13 October 2009

**Sydney Water Land Redevelopment at Potts Hill by Landcom
Re: Proposed Signage on Retaining Walls**

Council's traffic engineers have reviewed the proposed retaining walls, the associated signage and up-lighting to be placed on land which will in the future be owned by Council, and make the following comments:

BRUNKER ROAD ENTRY WALL
LONGITUDINAL ELEVATION 1:50

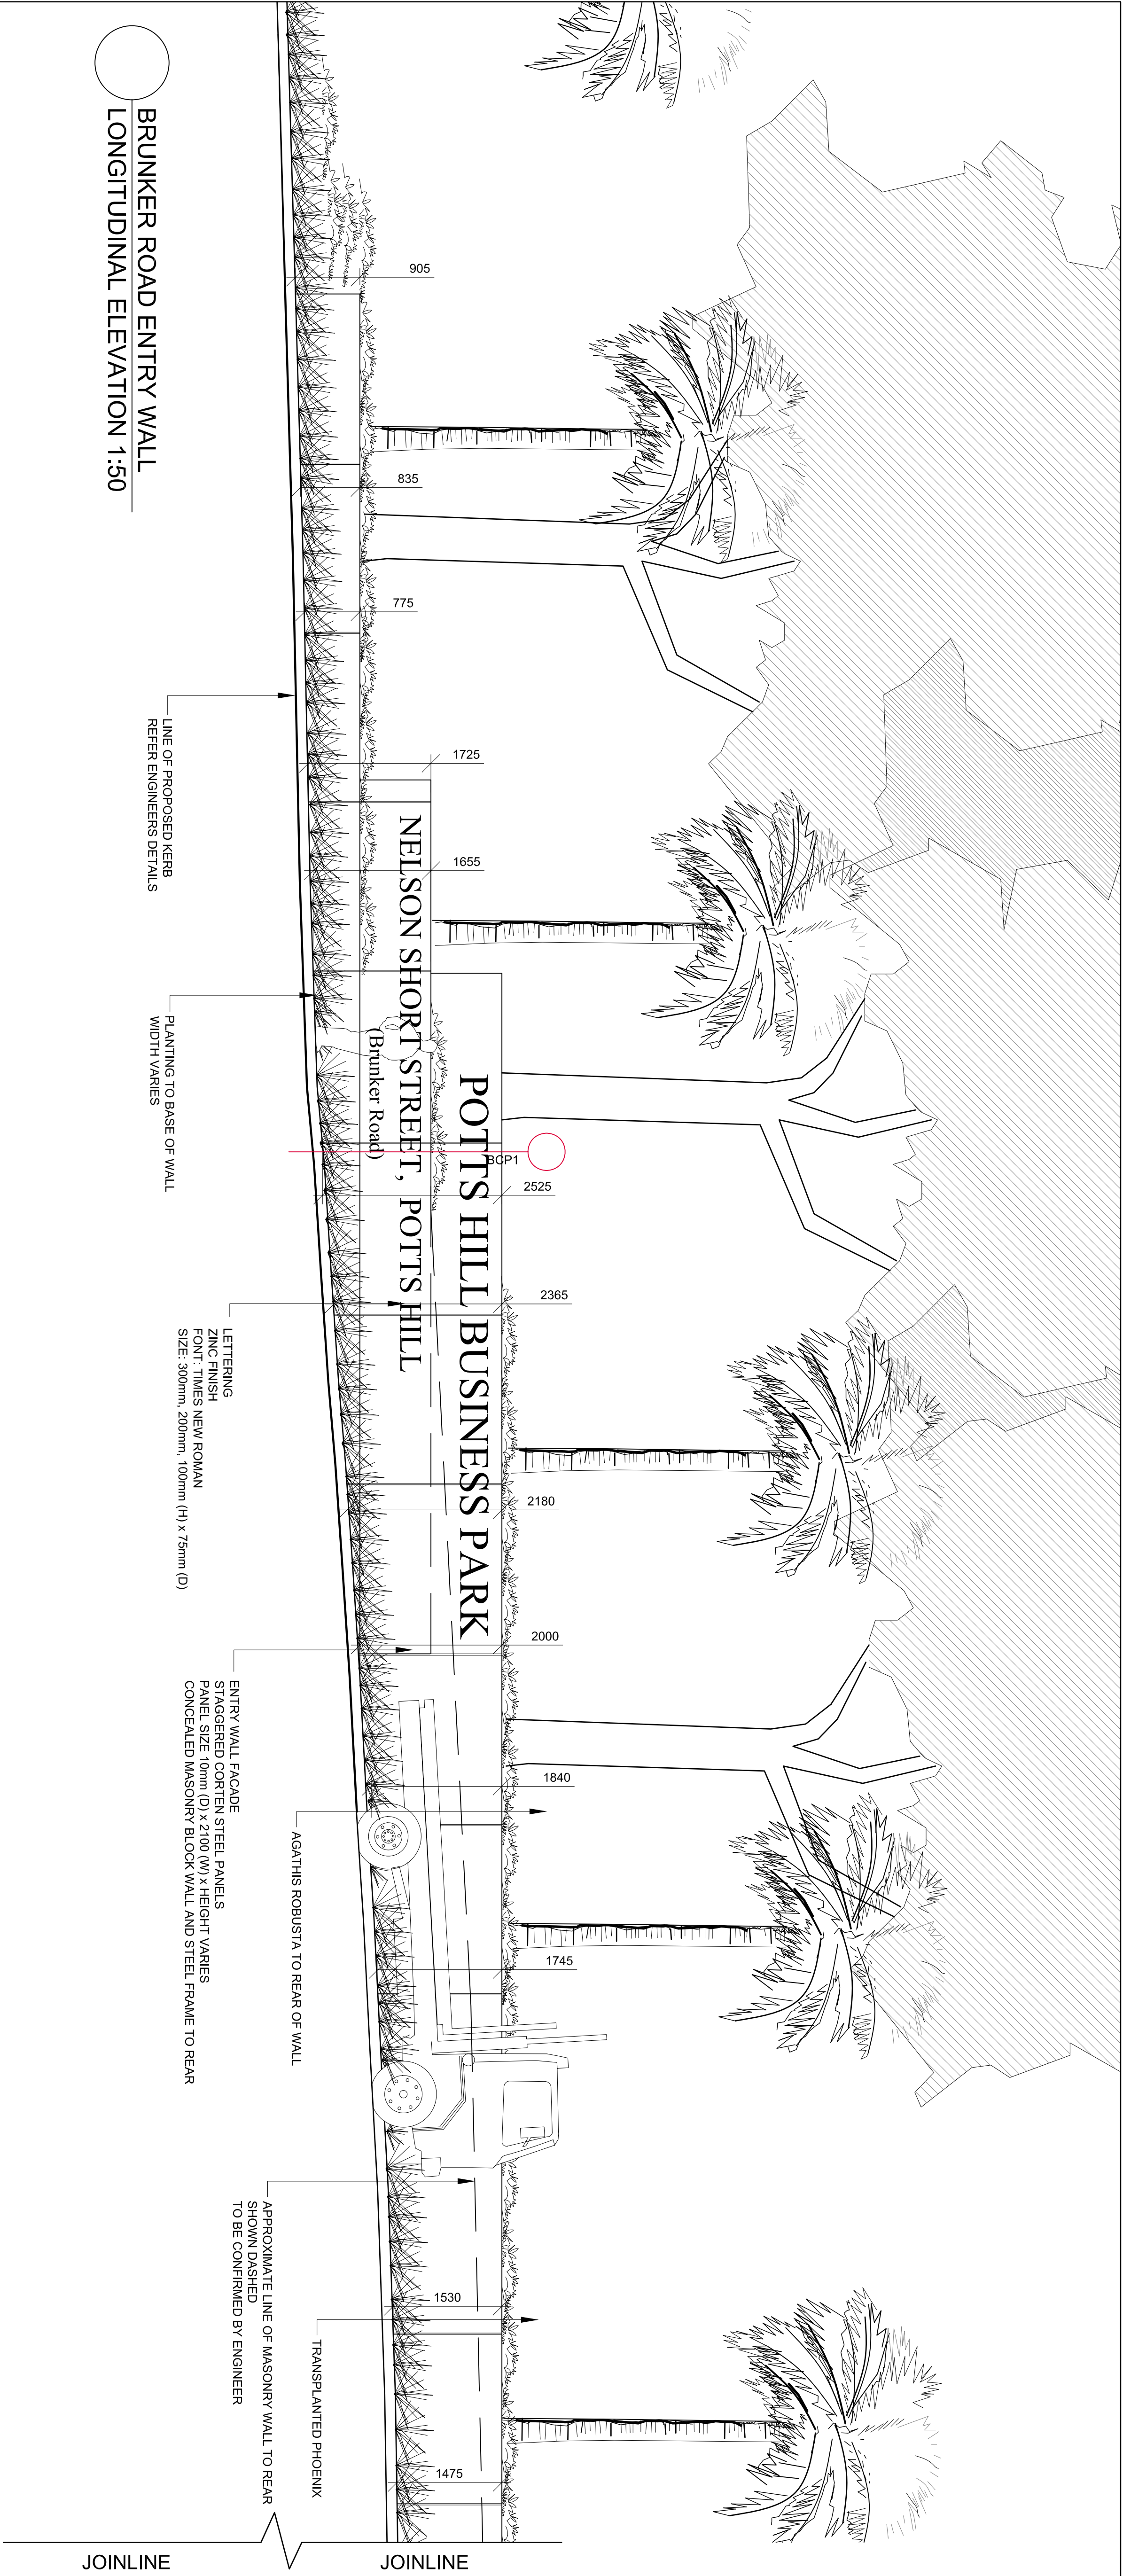
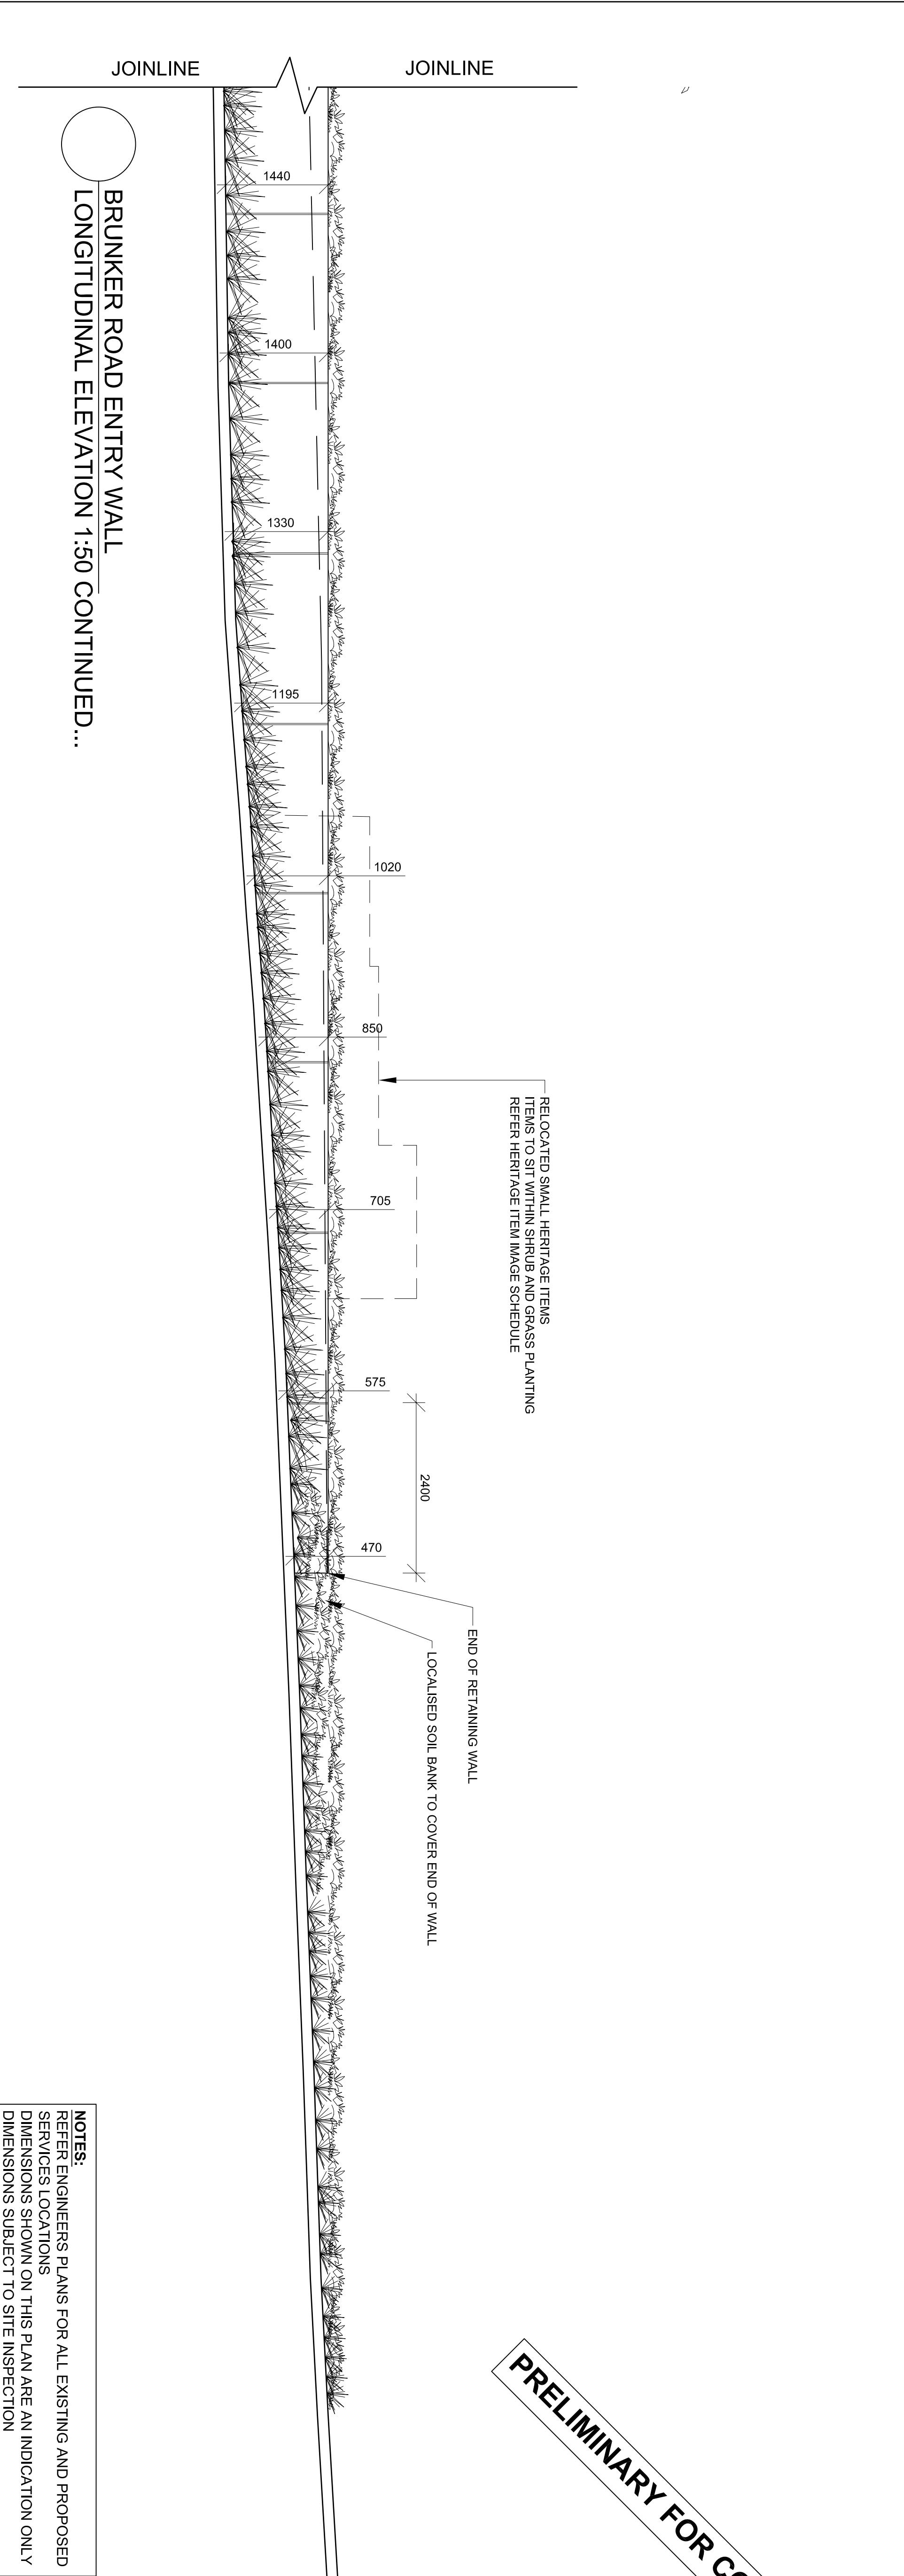
1. Council acknowledges that the proposed retaining walls, signage and associated up-lighting on the land at the entry of William Holmes Street and Nelson Short Street will be on land currently owned by Sydney Water, however will be dedicated to Council upon the completion of the subdivision applications.

4. Landcom and Sydney Water must acknowledge that should Council be required to undertake any road works or other works in the vicinity, that the retaining walls, signage and/or up-lighting may be removed to carry out these works. Should this occur, the works will be done at Landcom and Sydney Water's cost and be relocated and/or reconstructed at your cost.

5. Council makes no objection to the proposed signage lettering, as detailed on plans by Taylor Brammer being located on these retaining walls.
